Charlotte Department of Transportation

Memorandum

Subject: Rezoning Petition 08-086: Located on both sides of Victoria Avenue north of West 4th Street Extension and east of Johnson and Wales Way (revised 4/28/08)

SCHEMATIC SITE PLAN
 GATEWAY VILLAGE WESTERN ANCHOR PROJECT
 CHARLOTTE, NC

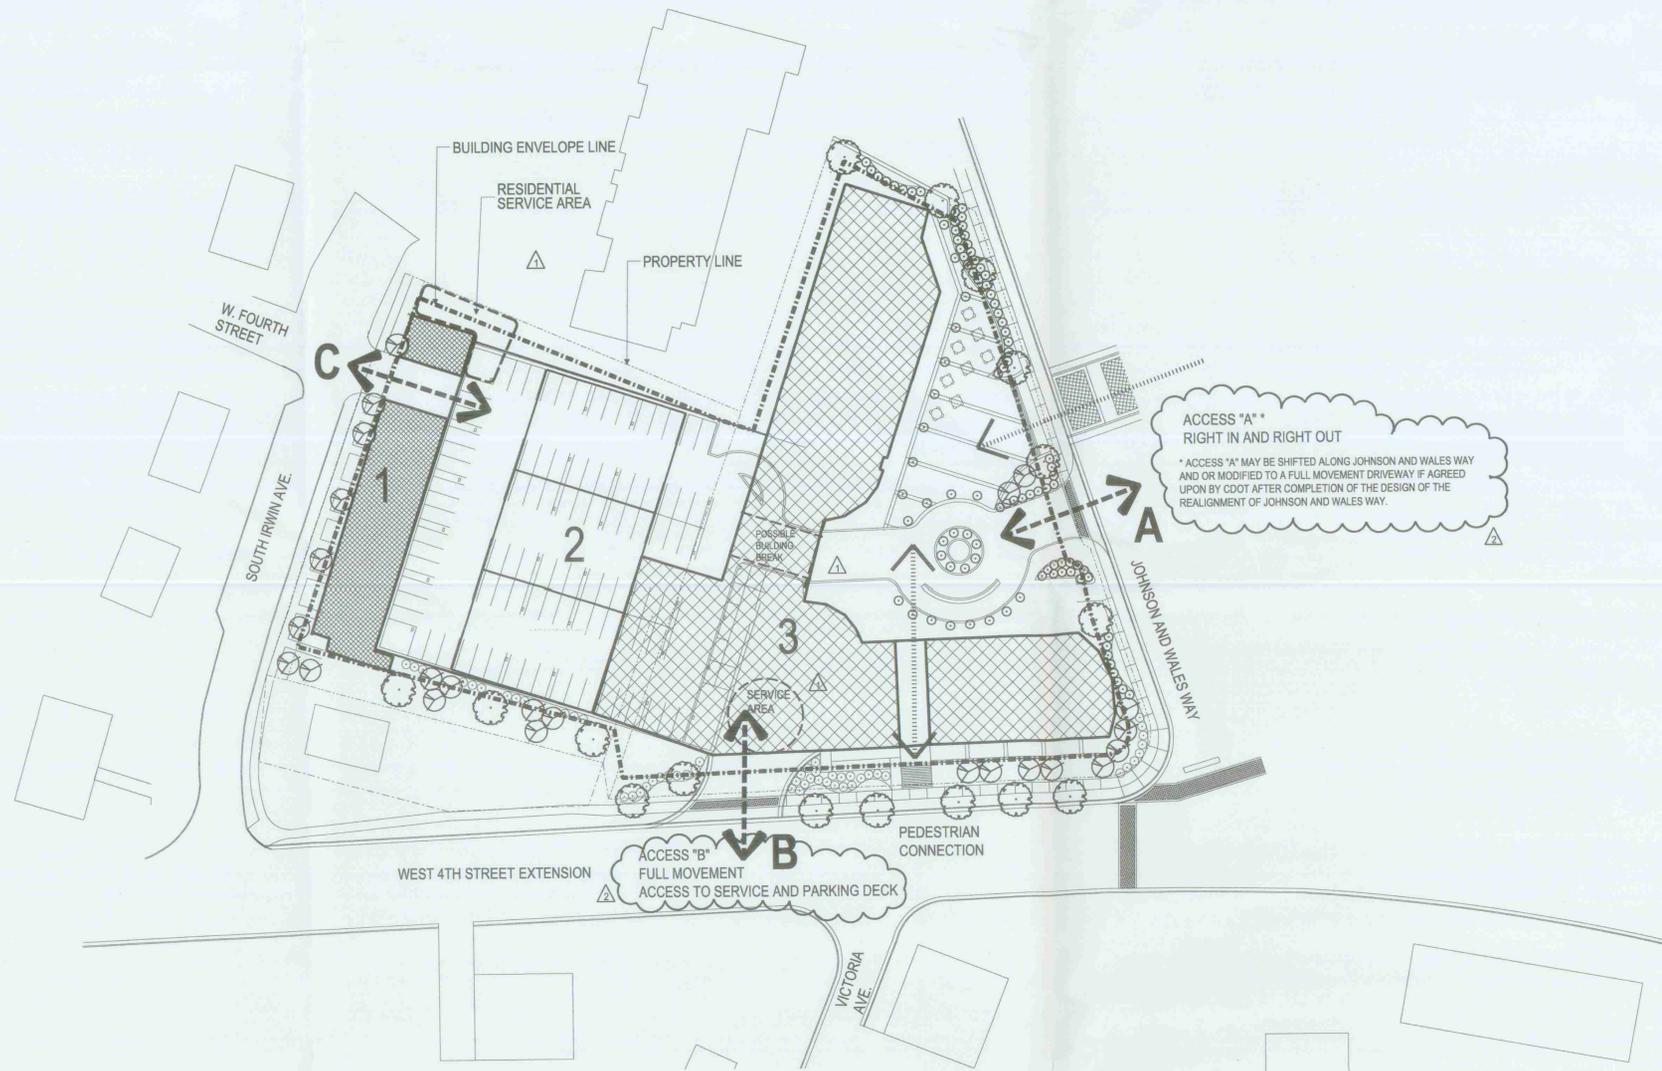
3. Due to the planned raised median, a full-movement access will not be approved on Johnson and Wales Way. We can support a driveway limited to right-in/right-out movements provided that the driveway is moved to a location towards the northern portion of the site and in advance of the proposed mid-block crosswalk location as determined by CDOT. As proposed, the driveway is located to close to the 4th Street intersection and needs to be in advance of the proposed crosswalk.

4. A mid-block crosswalk on Johnson and Wales Way is shown on the site plan. This crosswalk needs to be removed from the site plan or labeled as “proposed” and noted in the Development Standards to be conditioned on meeting the requirements of CDOT’s Mid-block Crossing Policy. Should the mid-block crossing meet the policy criteria, CDOT will determine the appropriate location for its installation at that time.

6. CDOT can support a full access driveway on 4th Street and South Irwin Avenue. The driveway on 4th Street needs to align with Victoria Avenue. If the driveway cannot be aligned with Victoria Avenue, then it needs to be located at the site’s western property line. The proposed parking deck needs to be served by the driveways from both 4th Street and Johnson and Wales Way.

TECHNICAL DATA SHEET
 GATEWAY VILLAGE WESTERN ANCHOR PROJECT
 CHARLOTTE, NC

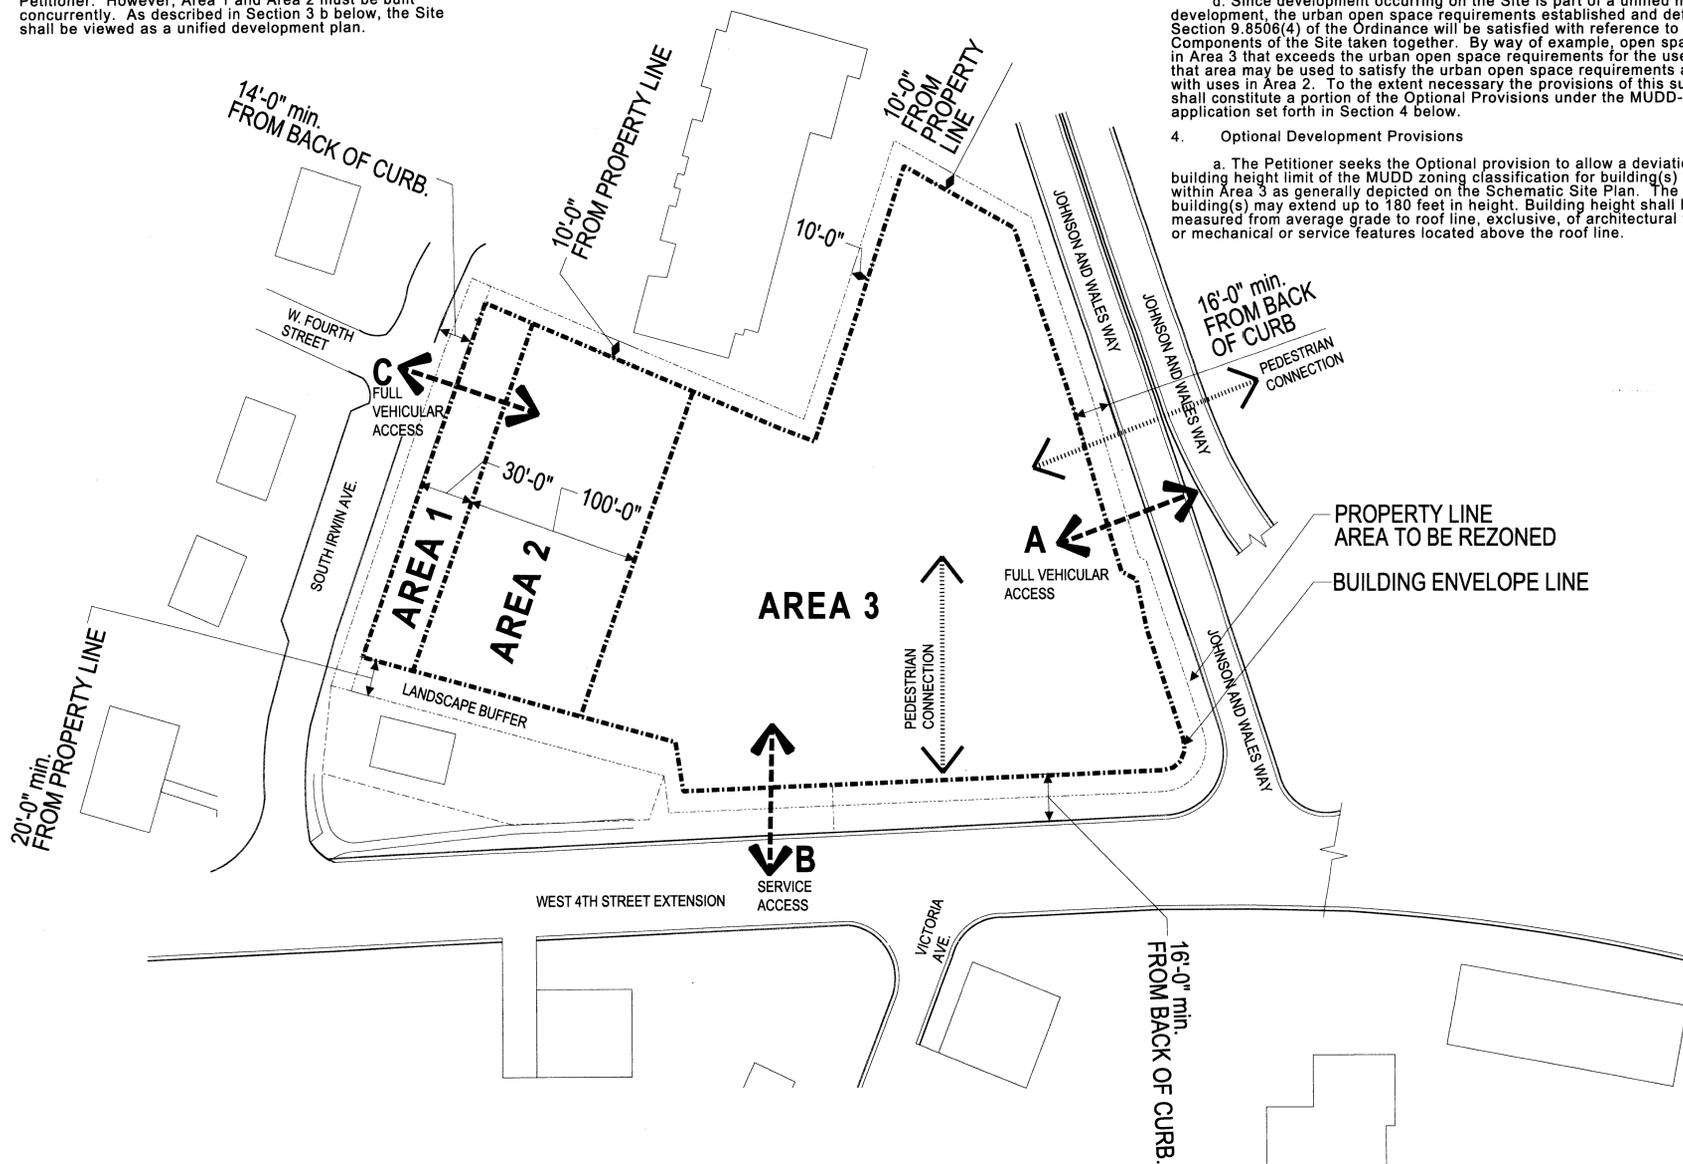
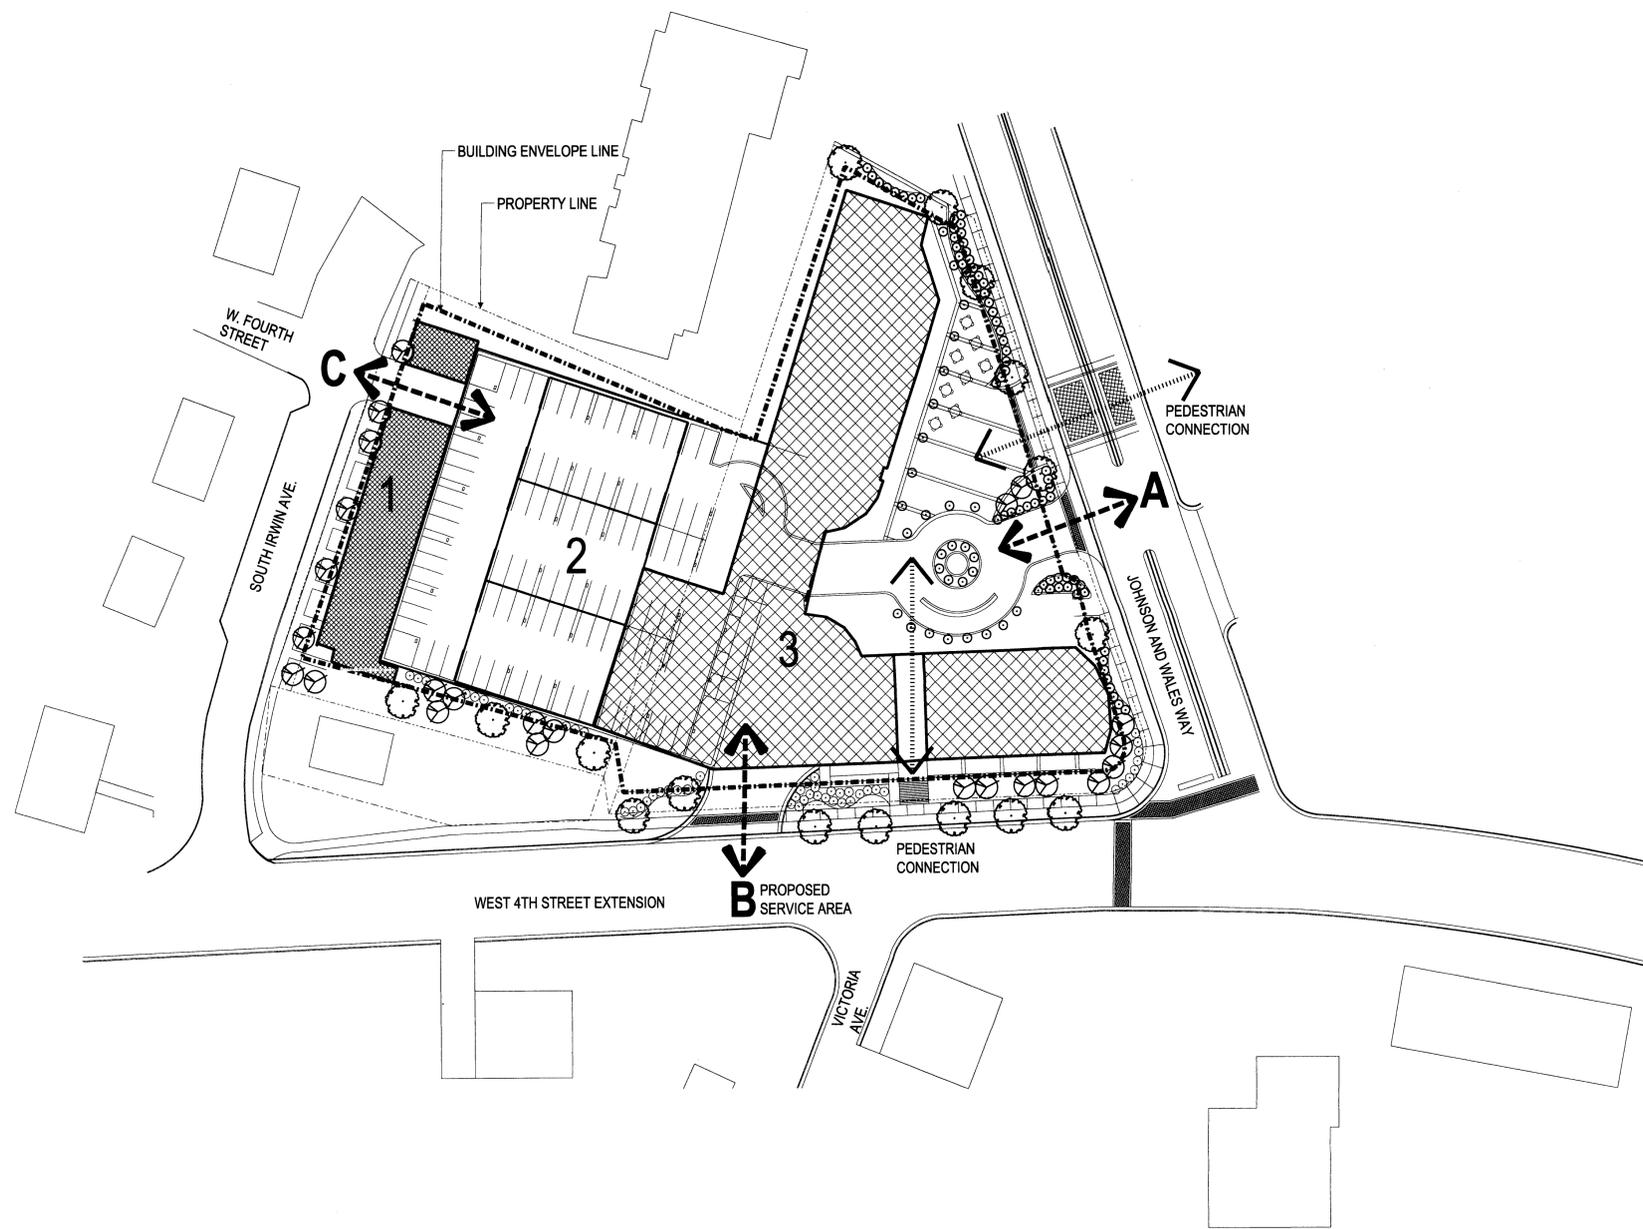
5. The building setback in the MUDD zoning district is to be measured from the back of either the existing or proposed curbline. The 16-foot setback will be measured from the back of the proposed curbline resulting from the final design of Johnson and Wales Way as described in 1 above.

7. The typical section on 4th Street fronting the site is yet to be determined, however it will likely transition from the existing four travel lanes at the intersection with Johnson and Wales Way to three travel lanes west of the site. The setback from the existing curb line needs to be 16 feet.
